**Cathedral Pines Filing 3, Lot 38 Amendment, VR-17-011**

Please accept the following comments from El Paso County Public Health for the vacation replat request referenced above:

FINAL PLAT CATHEDRAL PINES SUBDIVISION FILING NO. 3D

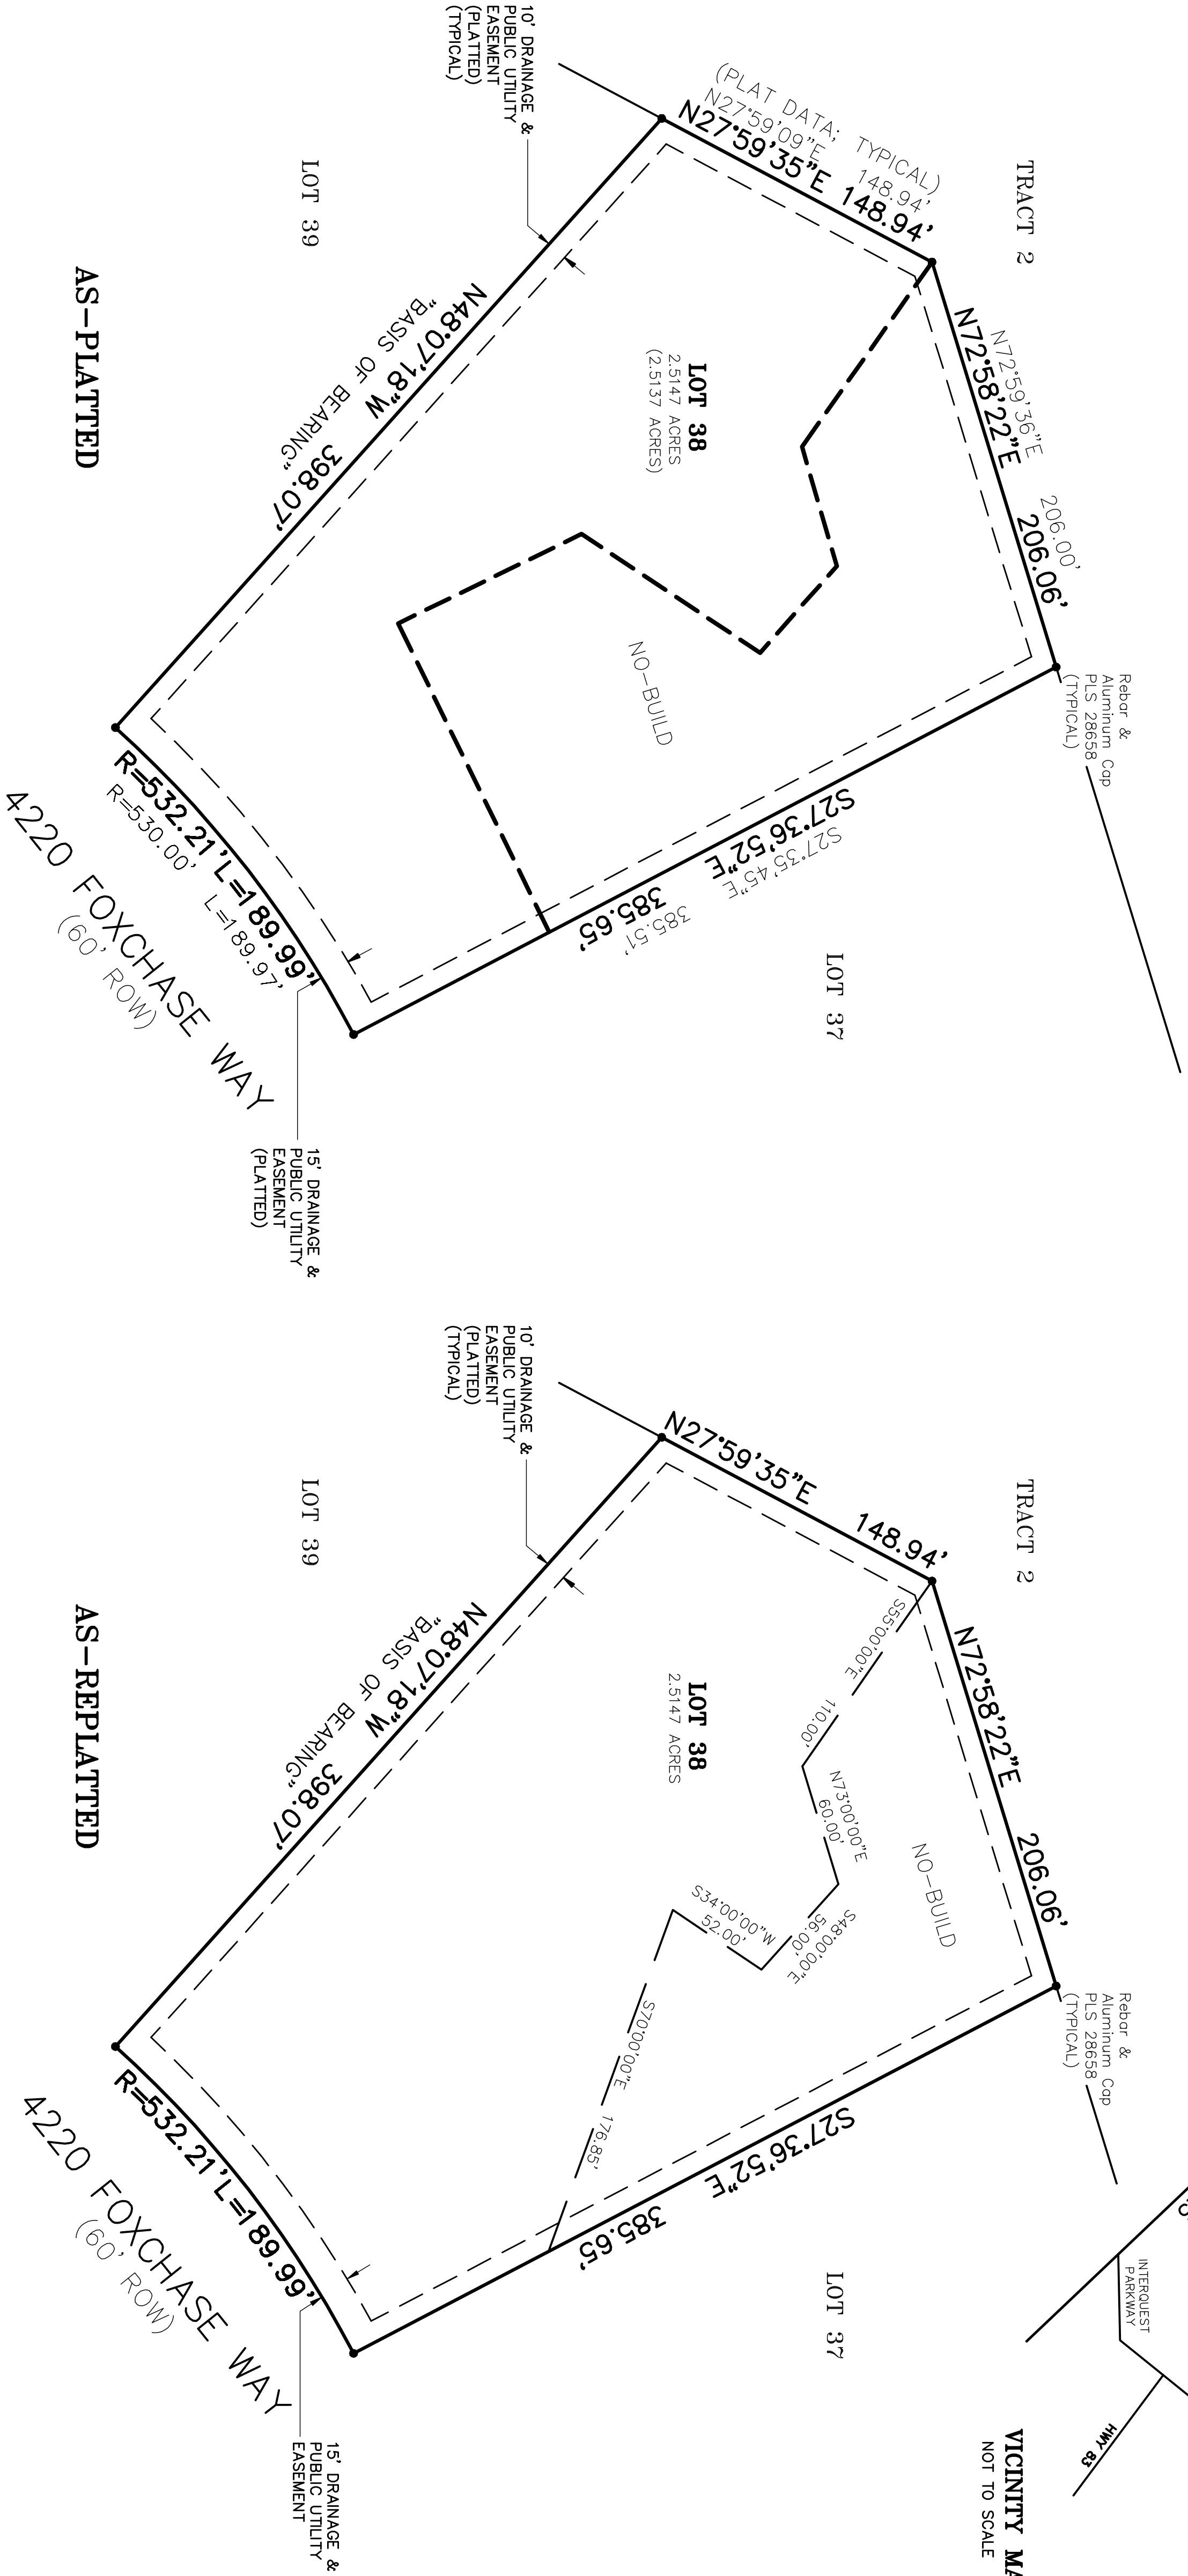
- El Paso County Public Health supports the proposed reduction of the 30% slope, no build zone on Lot 38. The increased amount of “buildable area” improves the ability of the property owner to better locate both primary and secondary sites for the onsite wastewater treatment system (OWTS), soil treatment areas (STA), locate the footprint of the house and to locate a private well and maintain minimum horizontal setbacks for all the OWTS components.
- During the site grading process the selected primary and secondary OWTS soil treatment areas must be protected from possible grading equipment compaction. Recommend protecting this area with orange construction-type fencing during the site development process.
